29 January 2016

File No: 2016/032384
Ref No: R/2014/38/A
Your Ref: SSD 6746

**RE: Staged State Significant Development Application for UTS Blackfriars
Precinct Research Building (SSD 6746), 2-14 Buckland Street, Chippendale**

Figure 2. Massing Diagram (Buckland Street Elevation, not to scale).

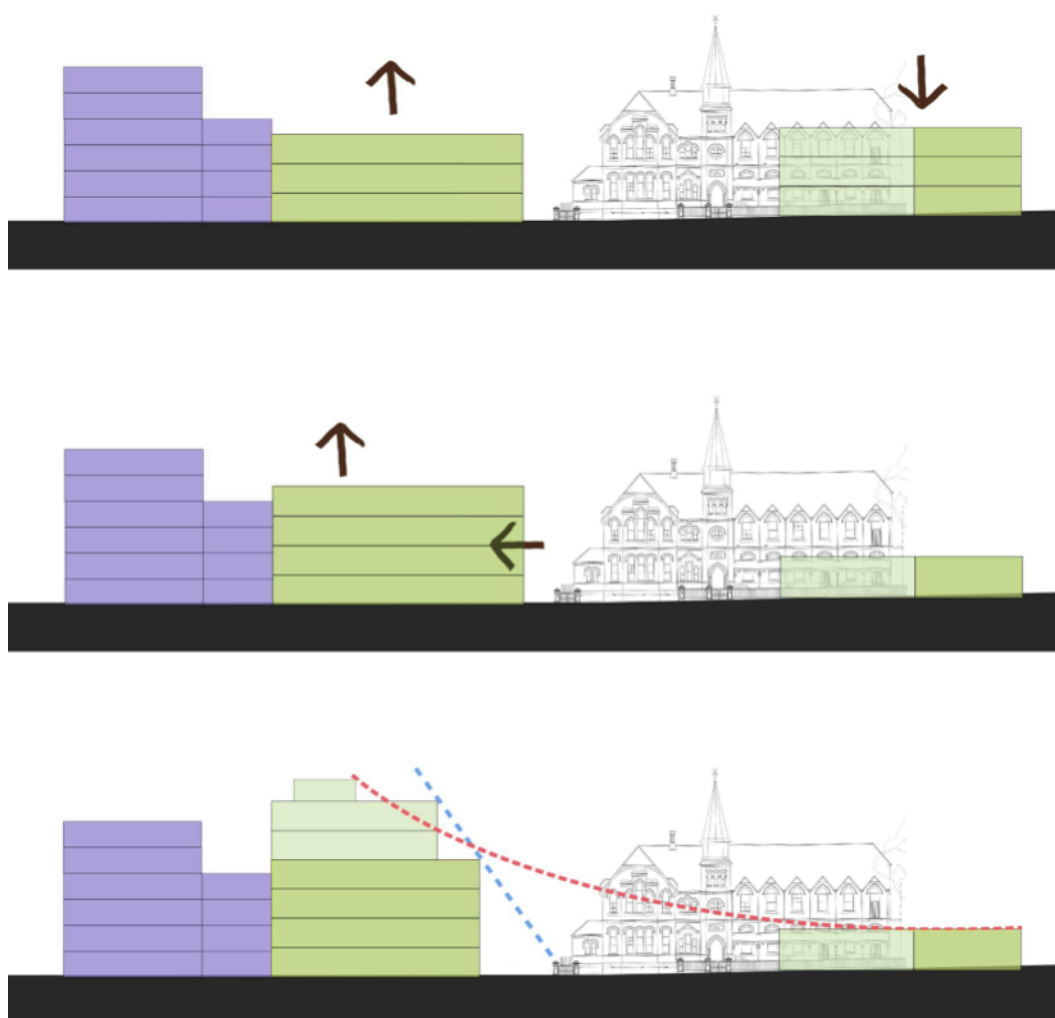
- The height of the proposed envelope is not consistent with surrounding heritage buildings and appears to exceed the height of the spires of CB22, CB25 and the spire of St Benedict's Church (UNDA campus). These spires should read as dominant elements across the two campuses.

- The proposed envelope overwhelms CB22 and CB25 due to its excessive height, bulk and inadequate setbacks. To mitigate these impacts, the envelopes height should be restrained if proposed setbacks are to be maintained. Alternatively, increased setbacks should be provided to CB22 and CB25 to provide adequate curtilage around these heritage buildings.

- If proposed setbacks to CB22 and CB25 are to be maintained, the height of the building should not exceed 4 storeys on the southern side in order to respond to the height of existing heritage buildings within the site and adjacent buildings along Buckland Street.

Figure 3. Extract from the architectural plans showing the proposed envelope on the site

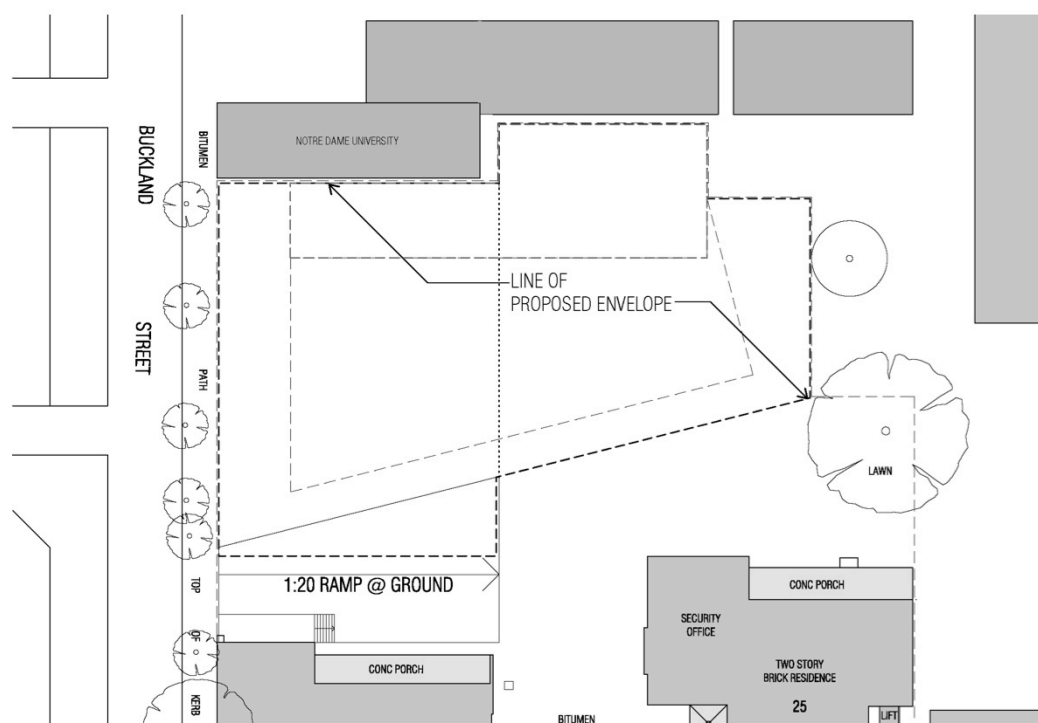
- The existing courtyard spaces make this city block distinct within the area, and respond well to the existing built form. The proposed splayed form of the southern edge of the building envelope not only conflicts with the established courtyard geometry, but creates awkward spaces and a narrow street entrance. An orthogonal building would respond better to the existing

- The proposed building envelope is represented in plan as a non-orthogonal shape with a splayed southern alignment created by striking a line between two points. The significance of the two points used to set up the splay is not described.
- It is acknowledged that the proposed building envelope does not represent the final form of the future building, however, the diagonal alignment of the envelope does not respond to, or respect the strong rectilinear character of the original site layout.

- The proposed envelope should be modified to an orthogonal form to reinforce the courtyard typology, at least on the ground level (see building from recommendations).
- T33, T34 and T35 are to be retained by setting the envelope back from Buckland Street. The width of the setback from the Buckland Street frontage should be determined as at least the minimum recommended by a qualified Arborist for the protection of the trees.
- No approval should be granted for the removal of street trees as part of this application. Tree removal to facilitate site access should be carefully considered during the detailed design and siting of the Buckland Street access point.
- A replacement tree planting strategy should be submitted as part of the Stage 1 development application that identifies suitable numbers, sizes and species of trees to offset any proposed tree removal.

- The building envelope should be modified so as to be parallel or perpendicular to the existing heritage buildings. Steps in the building envelope or future building footprint should relate to the existing courtyard typology and respect historic alignments (refer notation **F** in **Attachment A**).
